From: planning@cherwell-dc.gov.uk
Sent: 11 January 2021 16:06
To: DC Support
Subject: New comments for application 20/03619/F

New comments have been received for application 20/03619/F at site address: Heyford Park Camp Road Upper Heyford
OX25 5HD

from Tony Brummell land.drainage@cherwell-dc.gov.uk

PHASE 9, HEYFORD PARK - ATTENUATION BASIN LOCATION PLAN

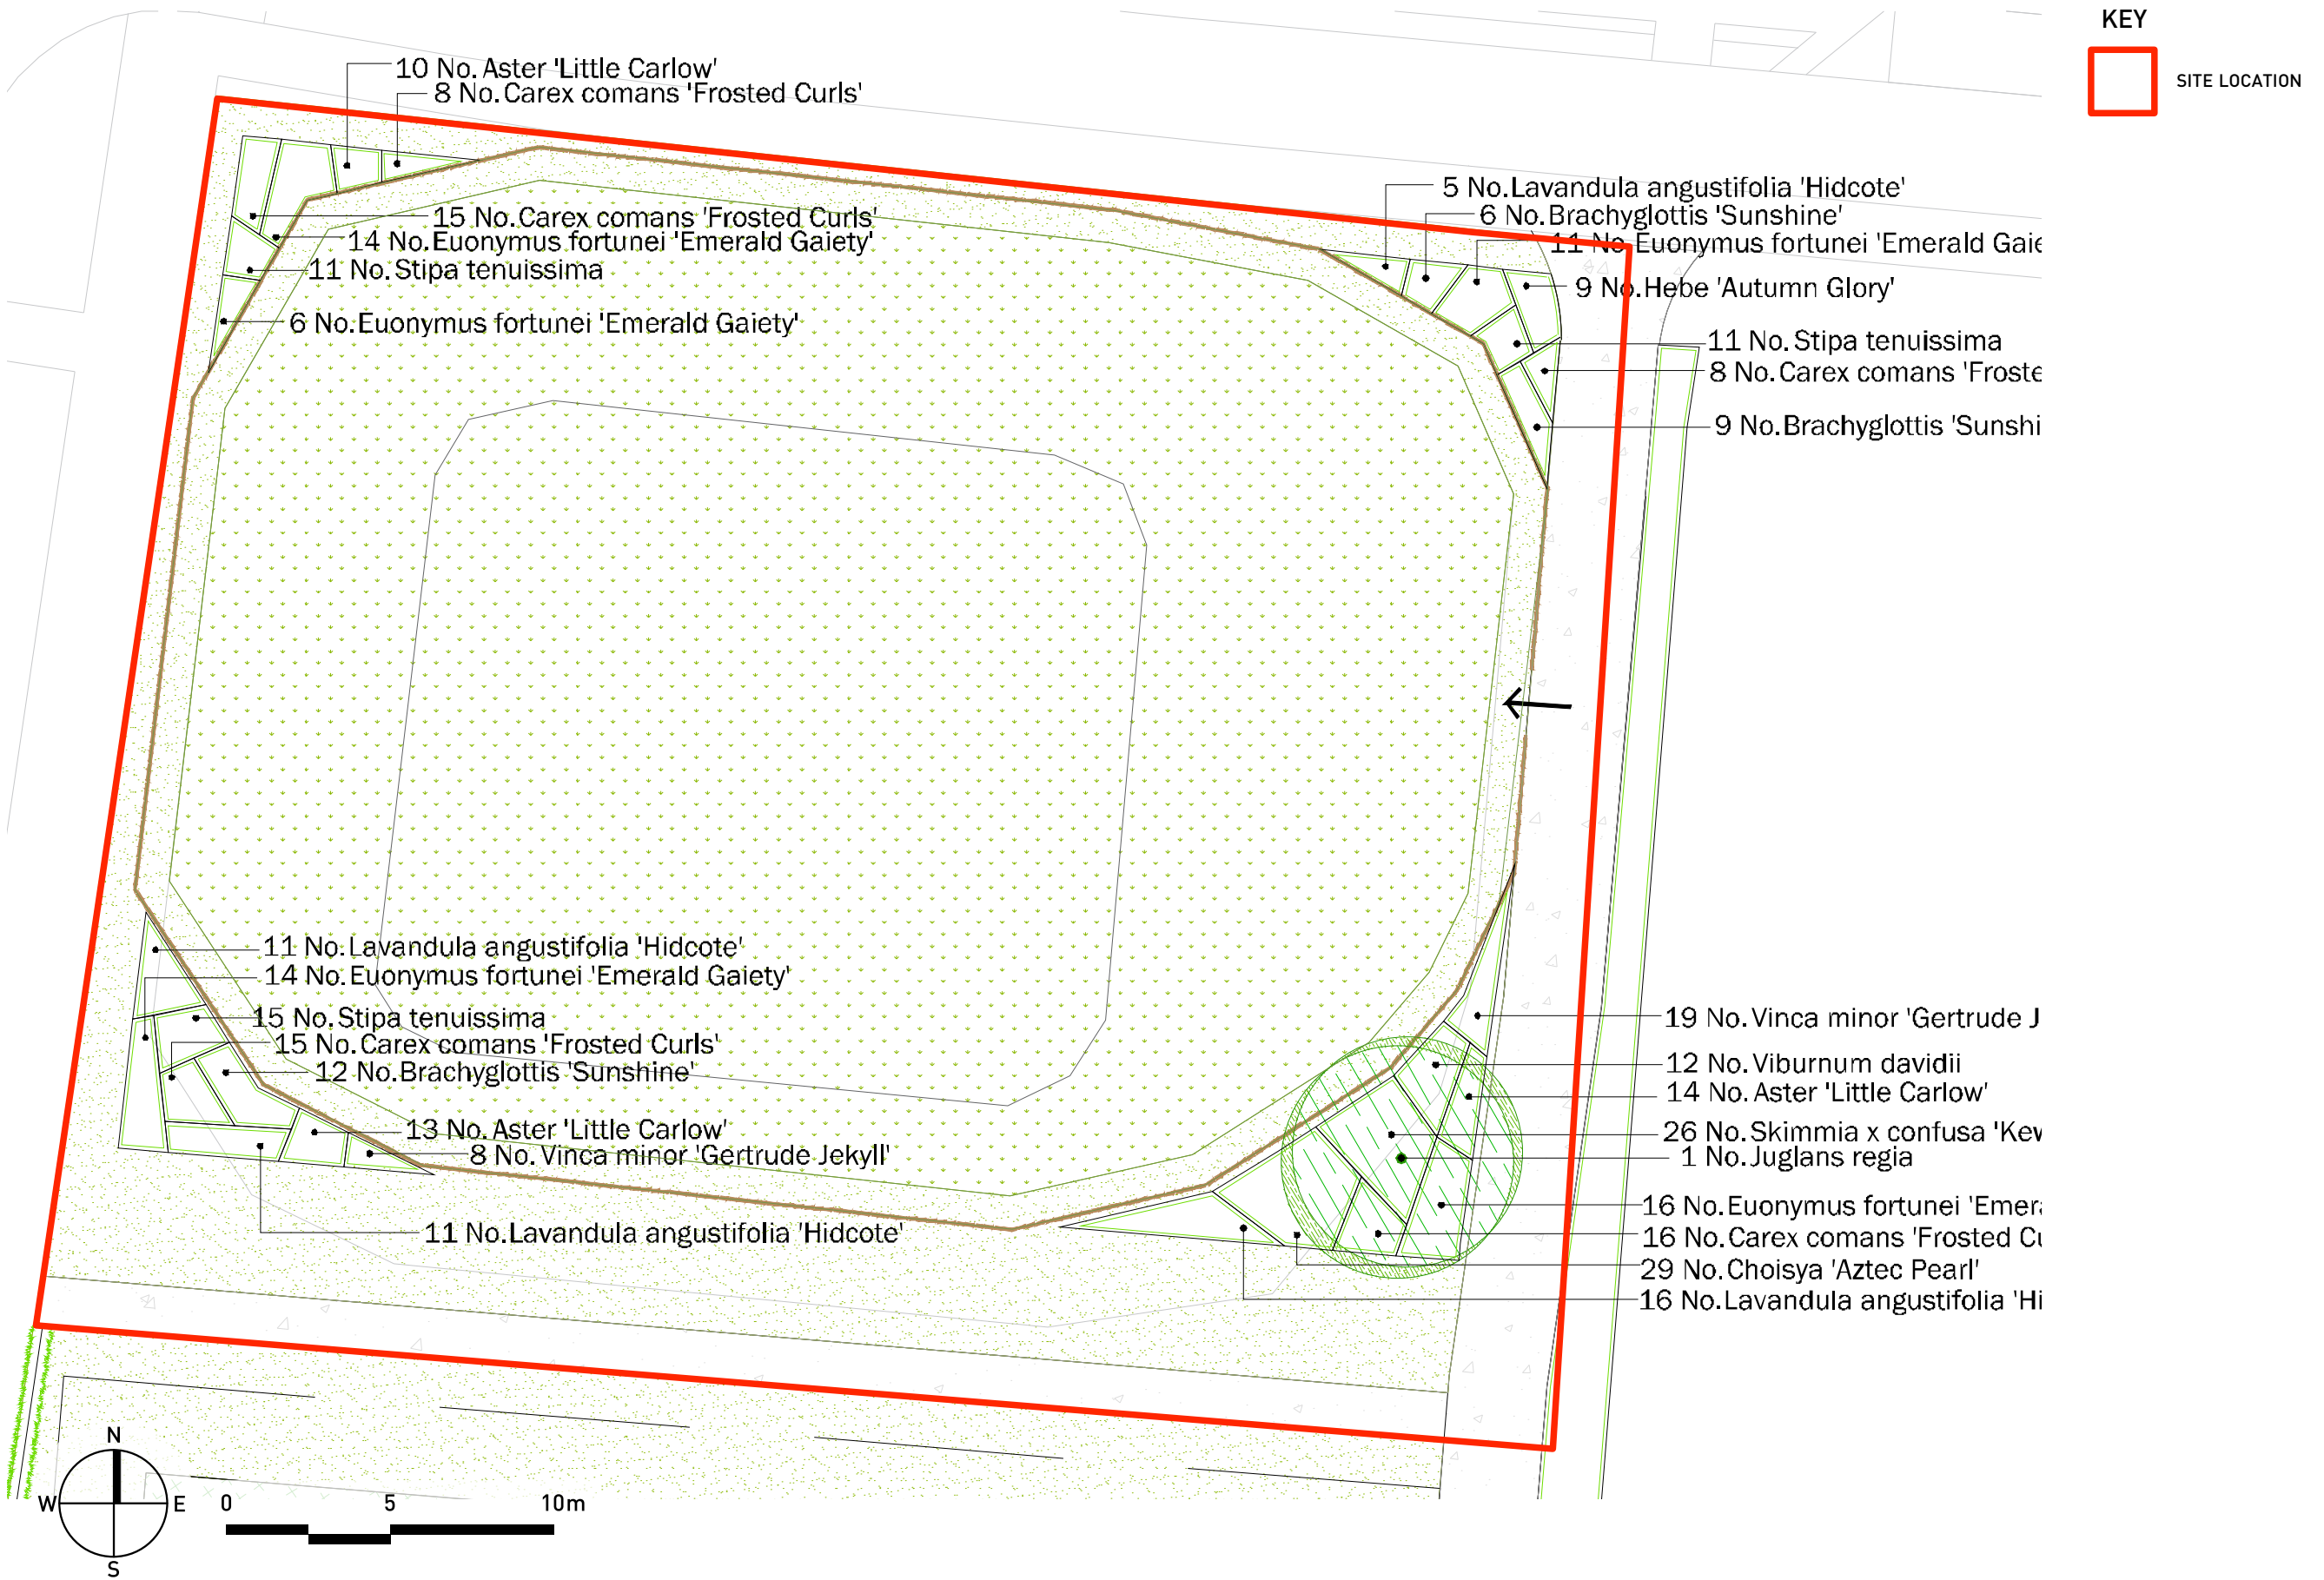
Clarification needed on attenuation volumes. Global FRA prepared by Peter Brett Associates indicates attenuation volume of 910.7 m³/ha (= 5021 m³ for the development served by this proposal), but only 3892 m³ is being offered. Further calculations are required to justify reduction. (perhaps due to having taken into account in-pipe storage and infiltration from swales?). Suggest Applicant's Drainage Engineer is requested to contact me.
